From: Ancient Monuments Society [ancientmonumentsociety@btconnect.com]
Sent: 16 December 2011 16:30
To: Jane Tucker
Subject: Re: Consultation on planning application 3/2011/0915 St Marys Hall, Stonyhurst
 Thankyou for your consultation .

Please can we have your comments on the above planning application? It is for the proposed refurbishment and upgrade of the ground floor central corridor and the conversion of existing changing rooms into scientific facilities. I have attached the formal consultation letter and listing description and here is a link to view the plans on our website

Refurbishment of Central Corridor & Provision of New Science Labs to Existing Changing Areas
Supporting Images - Identifying the Existing Corridor Space

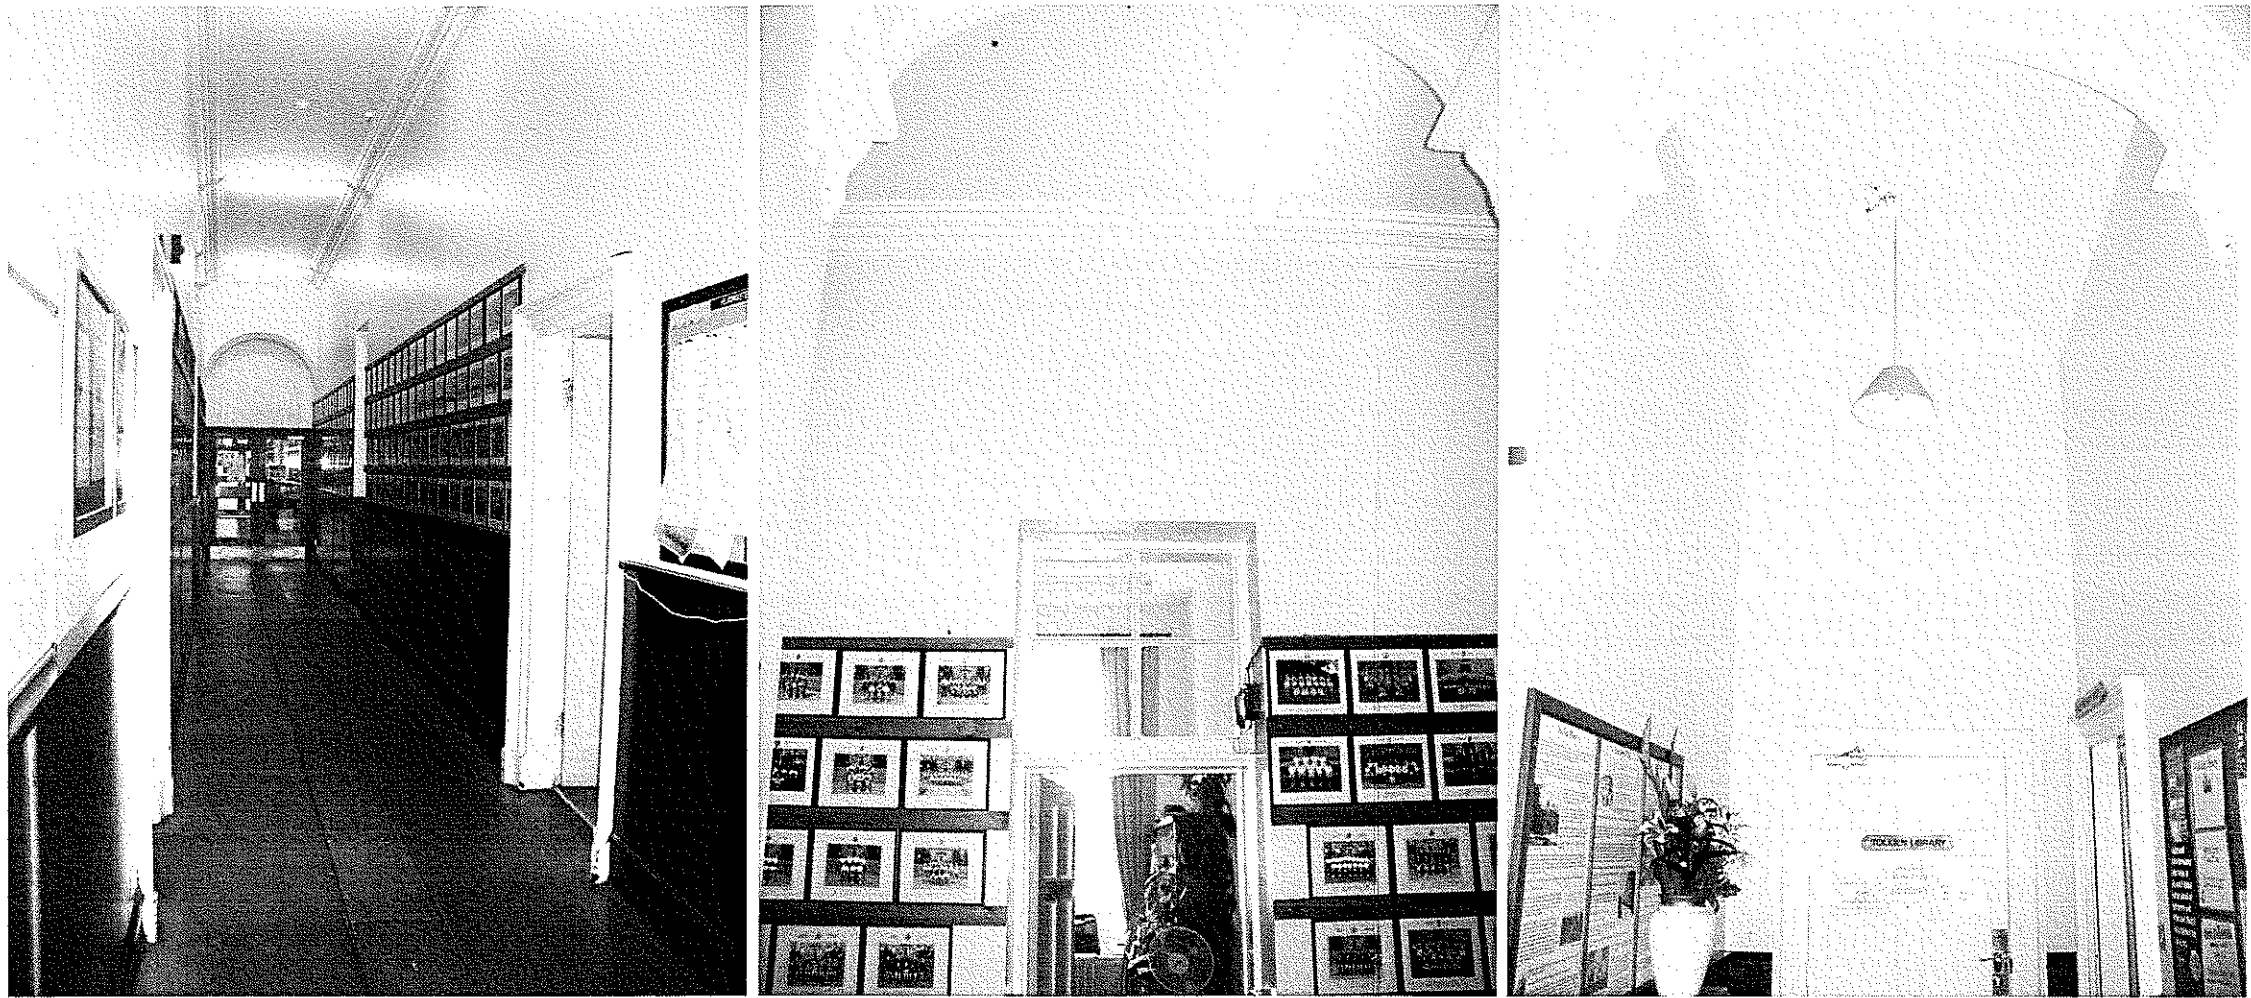
We are very concerned by the proposed suspended ceiling within the corridor.

The present proportions are attractive as are the archheads - and the new ceiling will be both visually damaging and claustrophobic in its effect
